# LSC Responses to Deviation Redline Comments

## DEVIATION REQUEST AND DECISION FORM

Project Name :	Rising Moon	Date: 11/1/2024
Schedule No.(s) :	5503101010	
Legal Description :	<b>TRACT B MORNING SUN I</b>	Please provide an exhibit with this deviation that includes items such as ROW width, roadway classification, and peak hour traffic at the intersection. <sup>1</sup>

Deviation Figure 1
**Subject Intersection Approaches/Street
Segments for Requested Deviations**

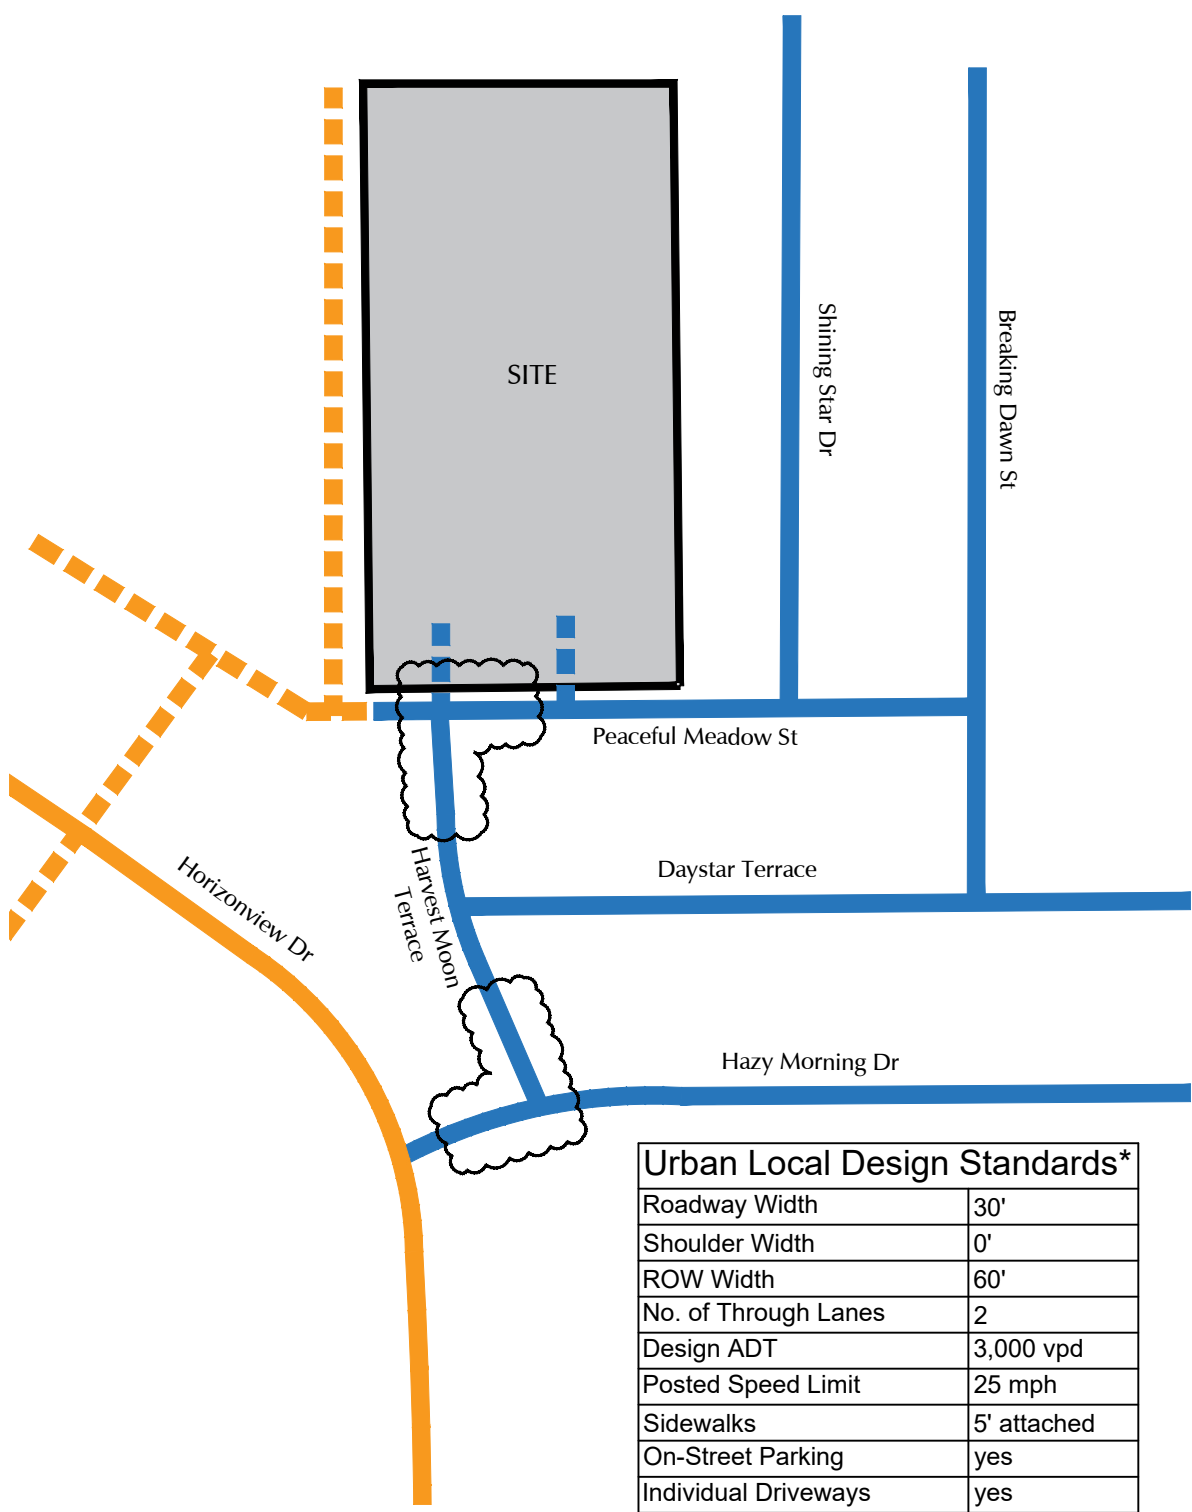
Please provide an exhibit with this deviation that includes items such as ROW width, roadway classification, and peak hour traffic at the intersection.

LSC Response: The deviation has been revised to incorporate exhibits, as requested.
